CITY OF ALBUQUERQUE

**RE: Event Center
1611 Airtech Ct. SE
Grading and Drainage Plans
Engineer's Stamp Date: 05/14/24
Hydrology File: N15D017**

Based upon the information provided in your submittal received 05/15/2024, the Grading & Drainage Plans **are not** approved for Building Permit and Grading Permit. The following comments need to be addressed for approval of the above referenced project:

SHEET TITLE
RETAINING WALL
NO. 3
PLAN & PROFILE

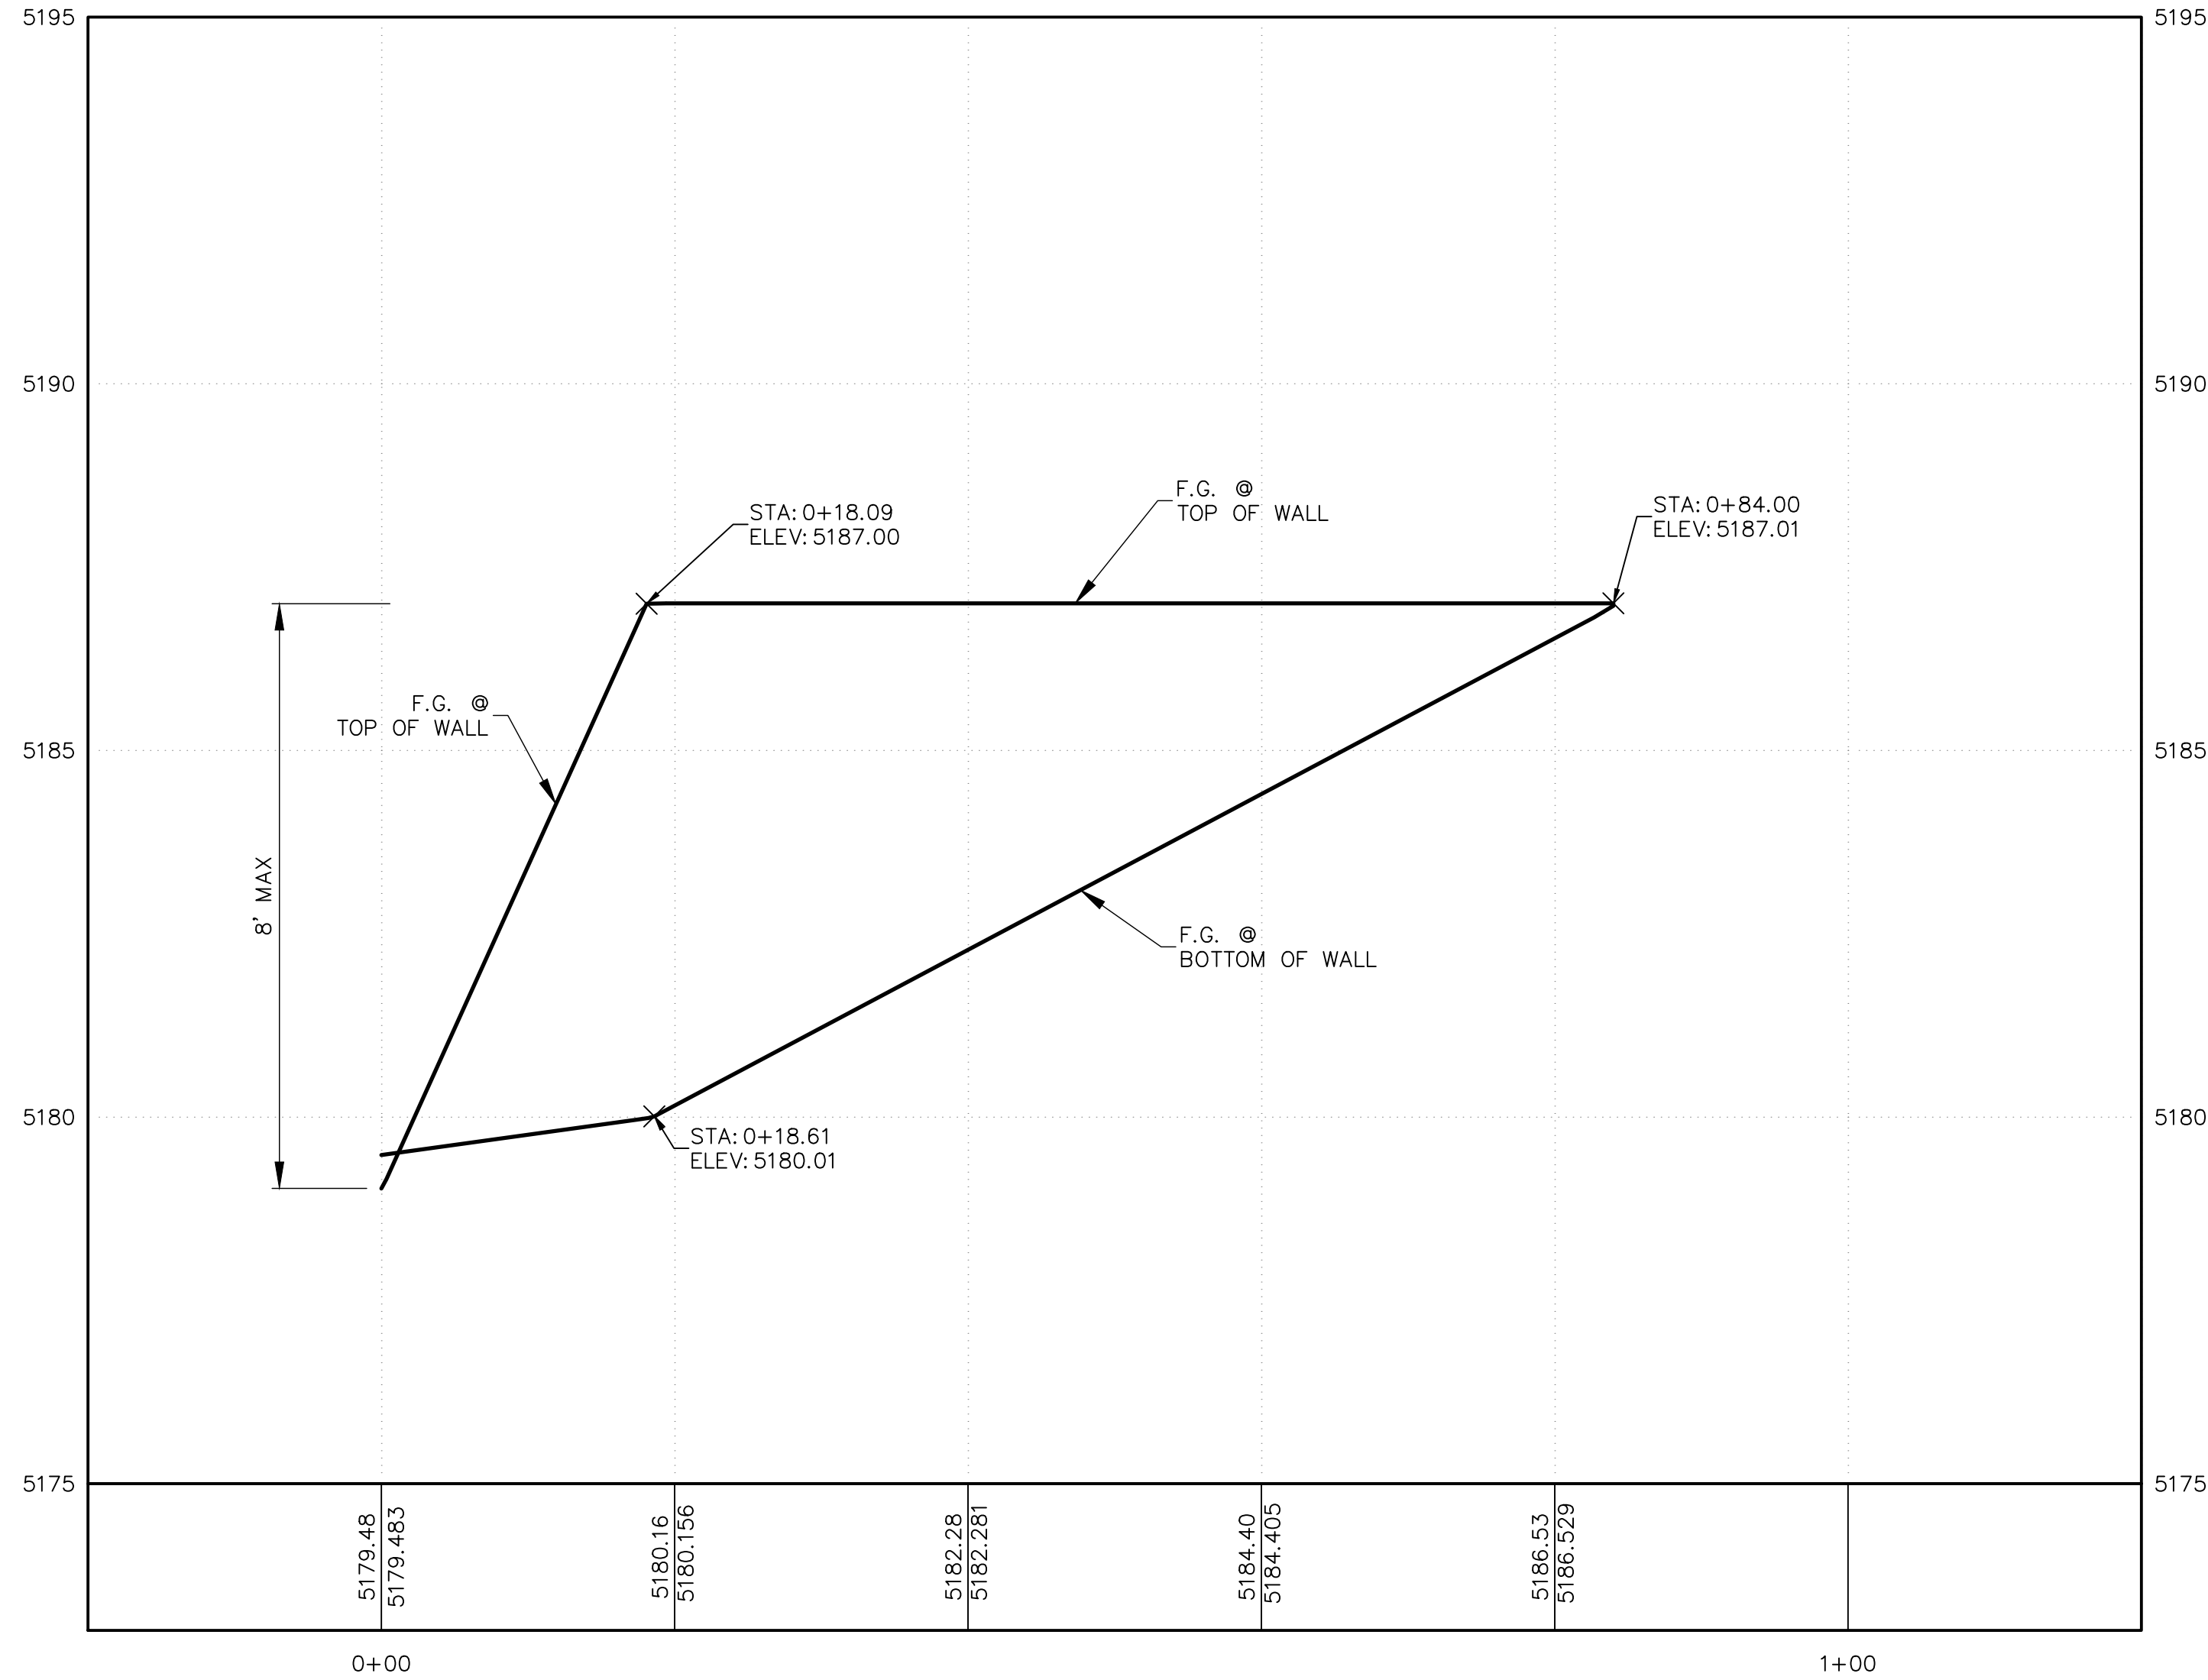
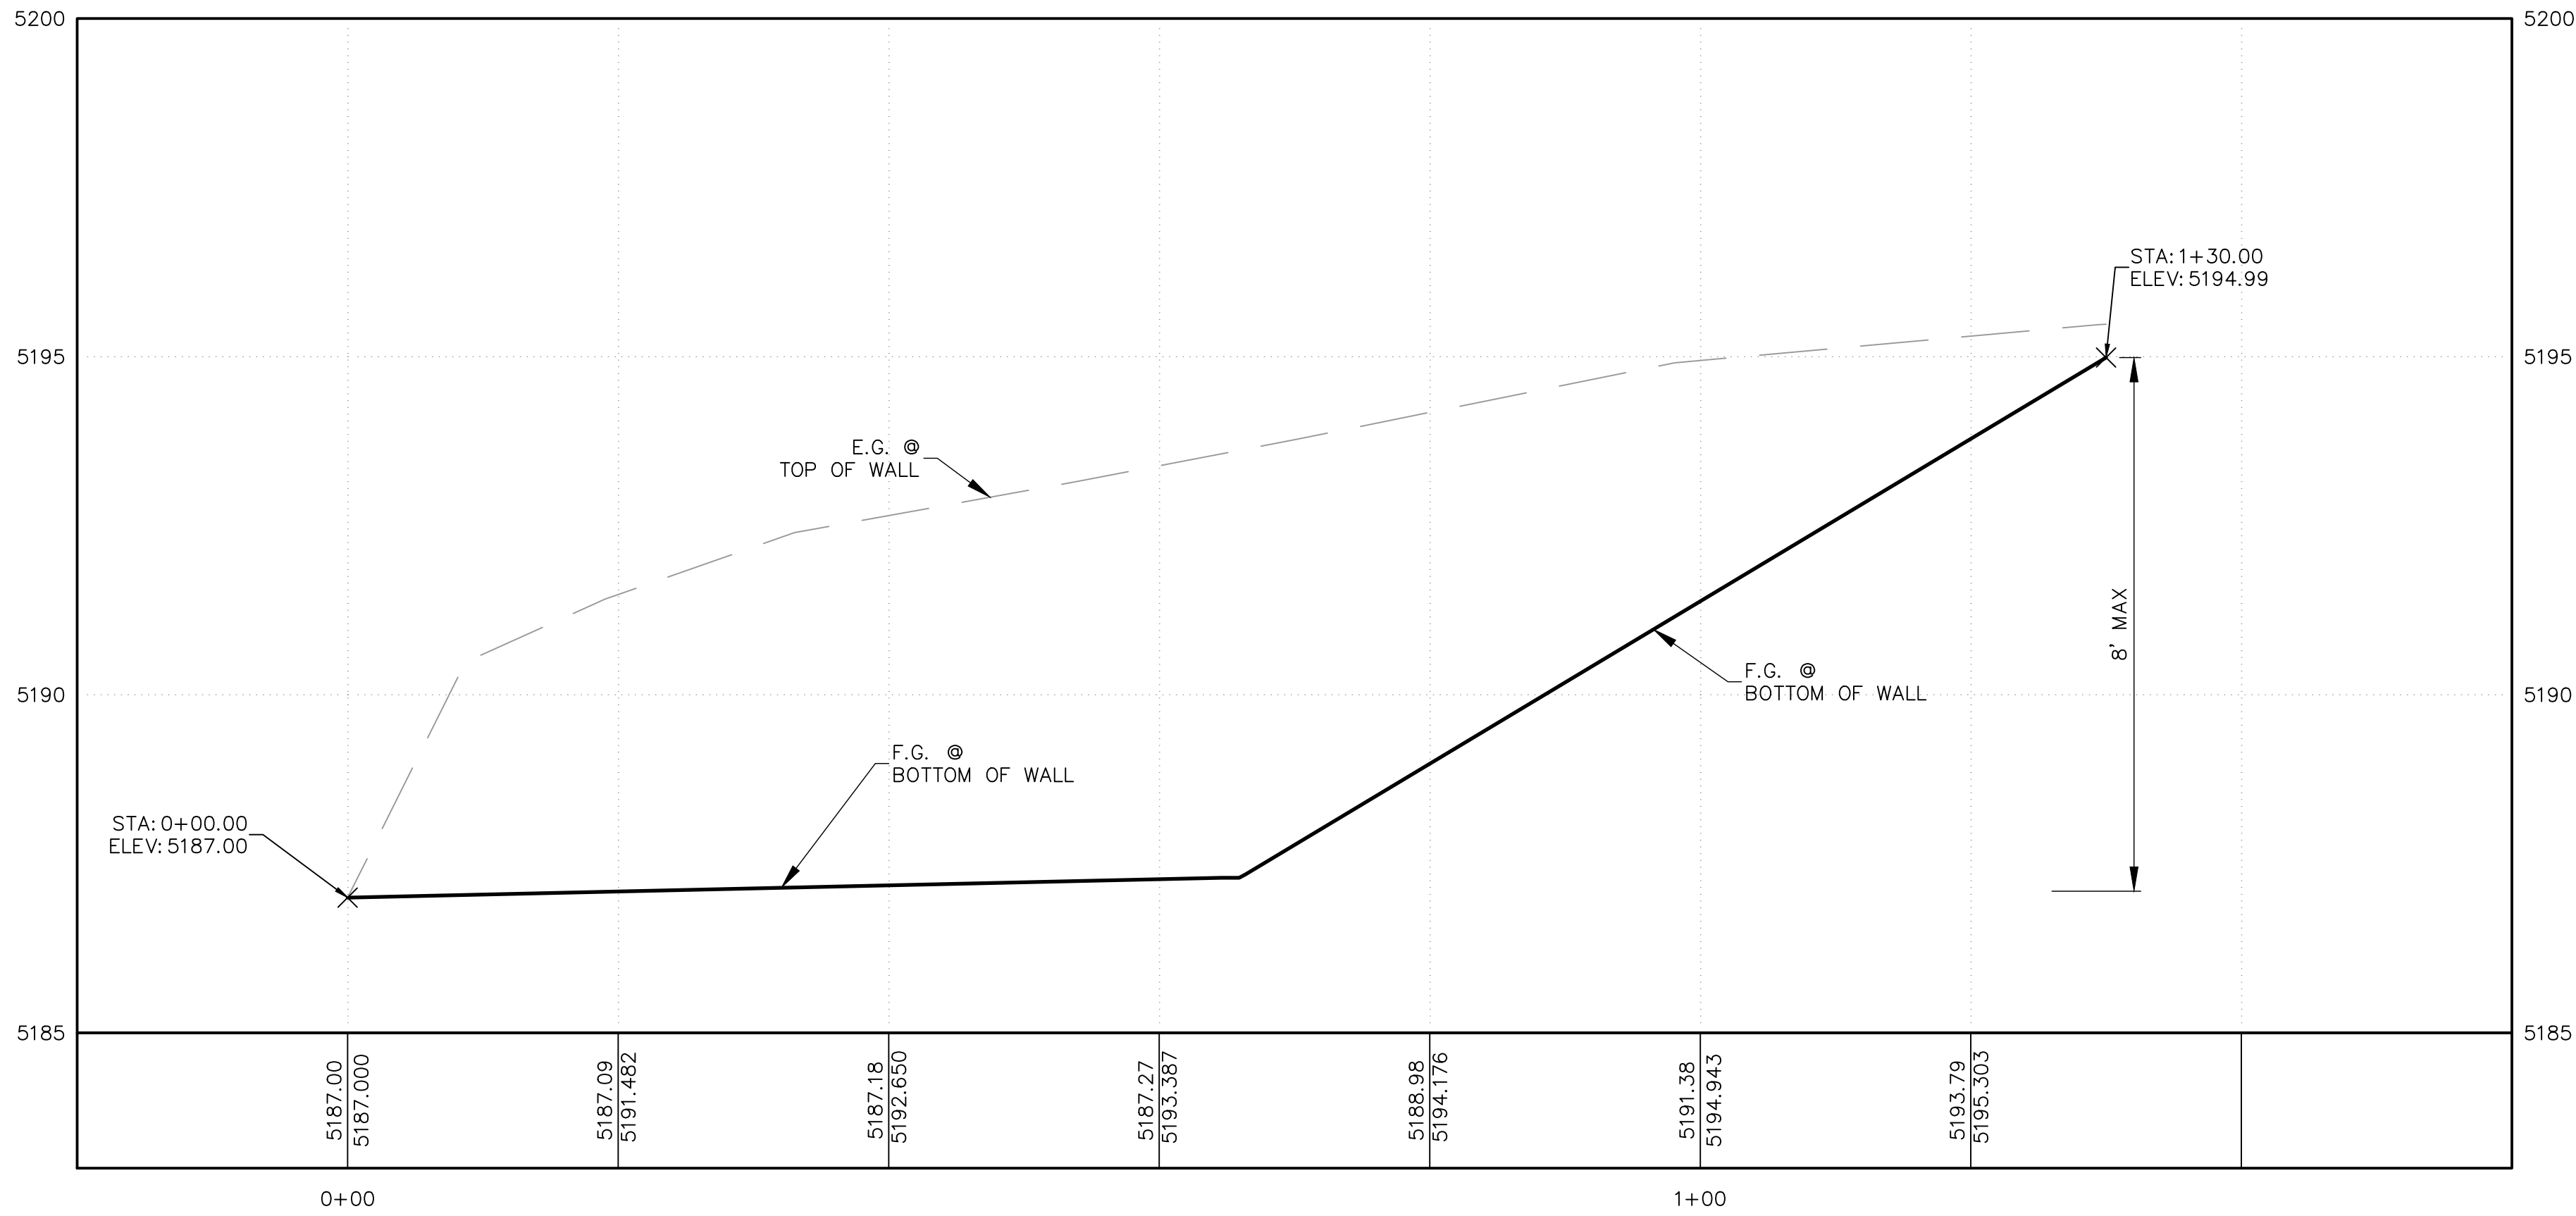
8. The retaining walls shown along the northern property line violates the IDO's maximum wall height of 8 feet in total height. These walls have a total height of 19 feet.
